From: Marge Schmuckal
To: Kandi Talbot
Date: Tue, Mar 16, 2004 10:28 AM
Subject: Re: Application #2004-0040

Rice St

354-A-003

I guess that I am not following your logic. I am assuming this is a change of use from warehouse/industrial use to general/business offices. And that is why there is a requirement of site plan review. All the uses in the building (including the past approved industrial warehouse use) must be included for purposes of parking. The uses would breakdown as such:

SD-1

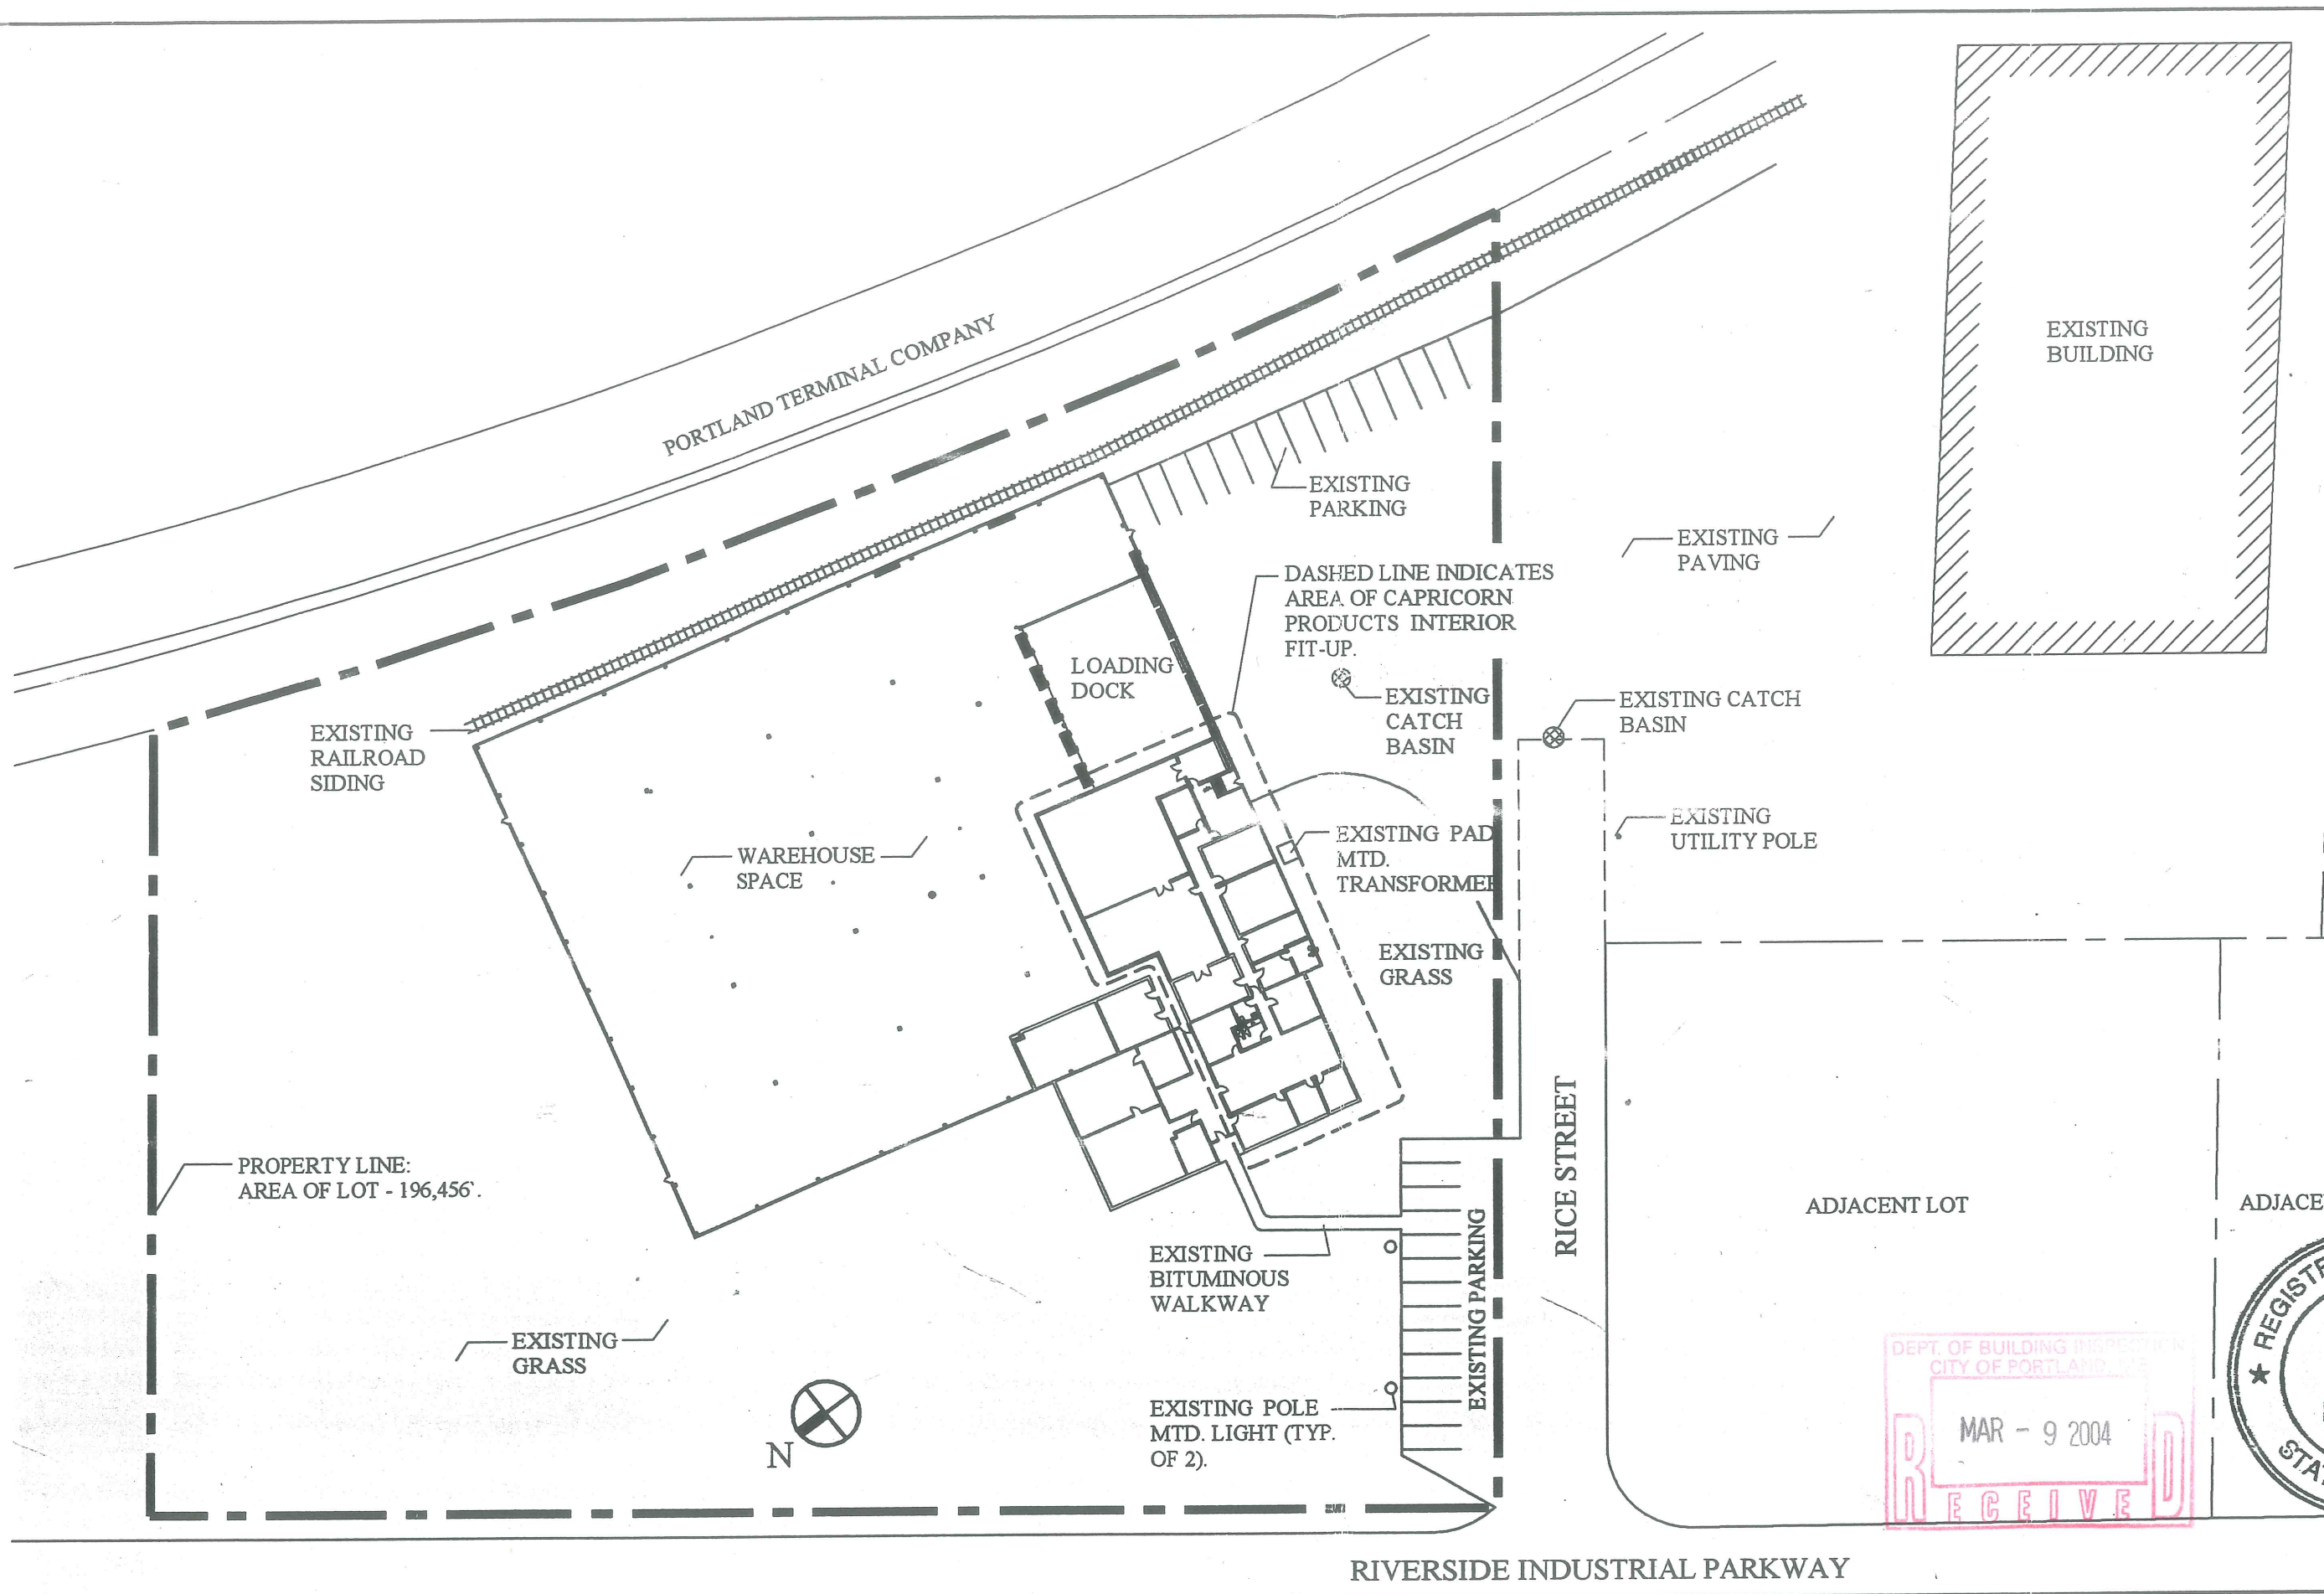
a total of 69 parking spaces are required. I have only counted 27 spaces on the submitted site plan. I have no narrative of uses attached to my site plan application. Was there something else submitted other than a site plan from David Lloyd?

Results: They are short on parking.
